Please ask for: Mrs D Johnson
Email: daun.johnson@arun.gov.uk
Telephone: 01903 737762
Our Ref: BE/119/20/PL
Your Ref:
Date: 20th October 2020

Application for Planning Permission

Development: 1 No. detached house. This site is in CIL Zone 1 (Zero Rated) for new dwelling.
Location: Land West Of New Barn Lane Bersted PO21 5DN

- Roof - Grey flat tile
- Brick - Buff

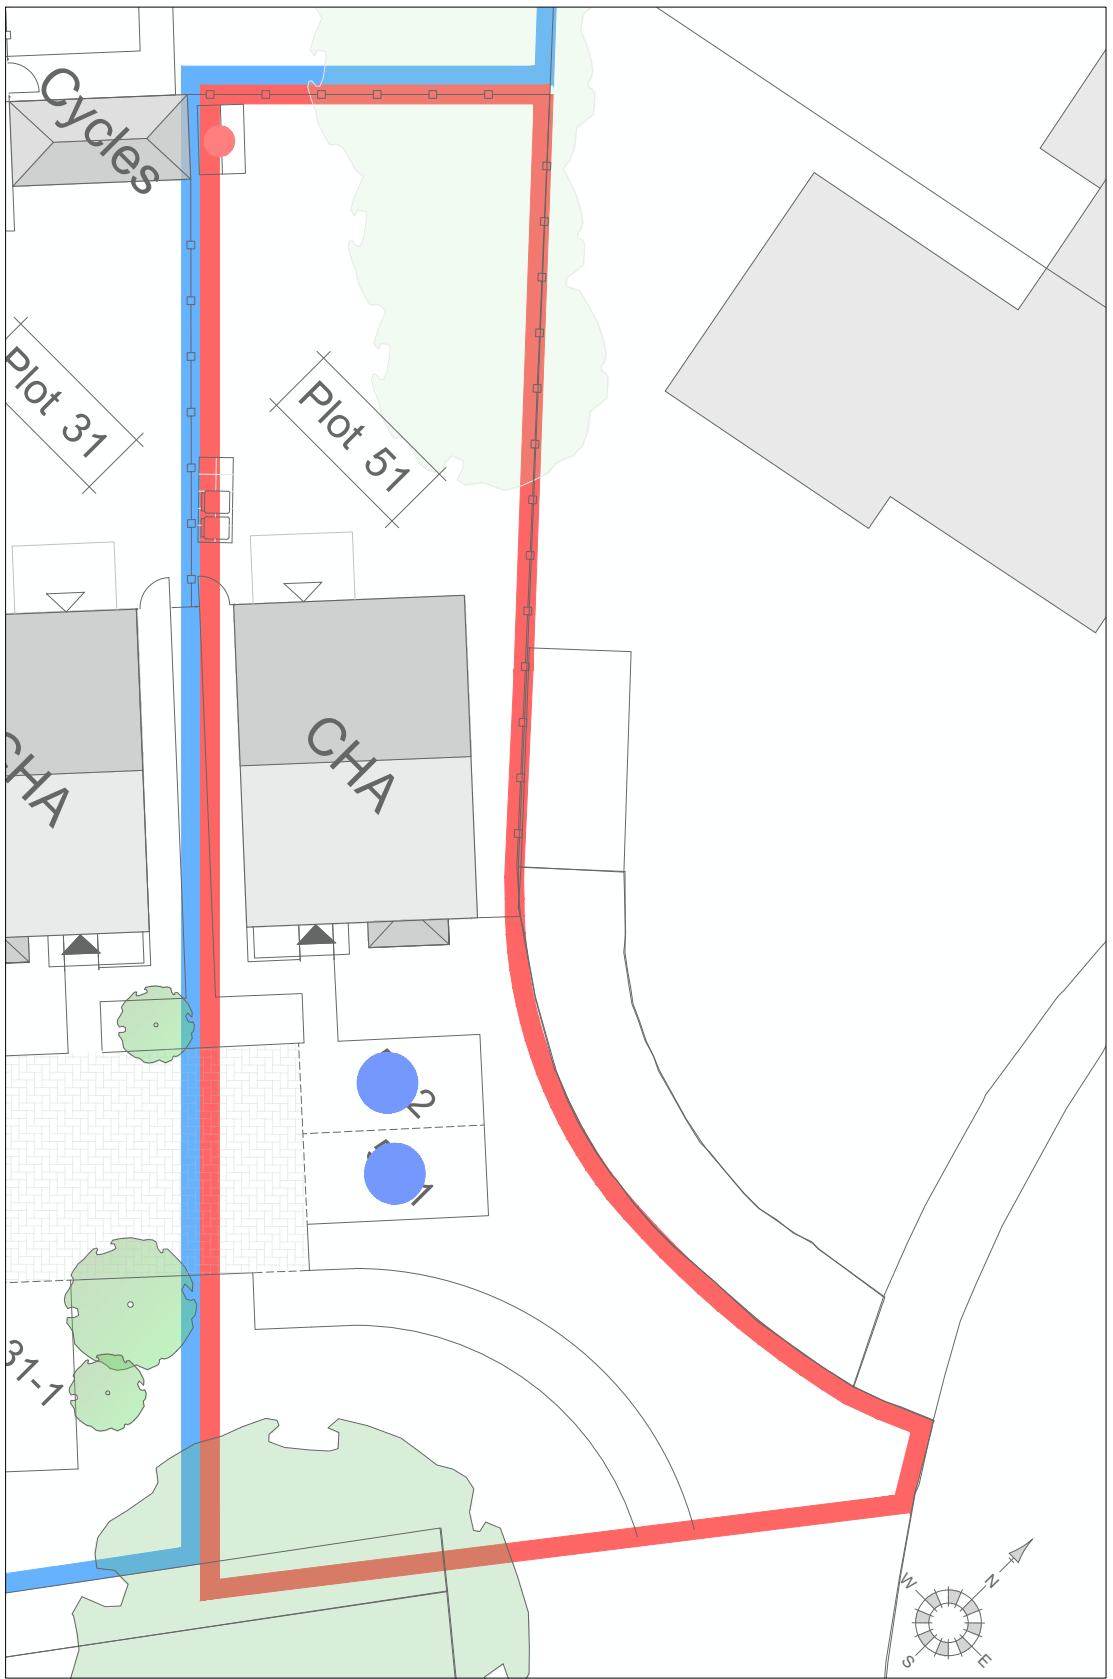
On the Block plan, please provide measurements from the proposal to the site boundaries and show the access from the road to the proposal.
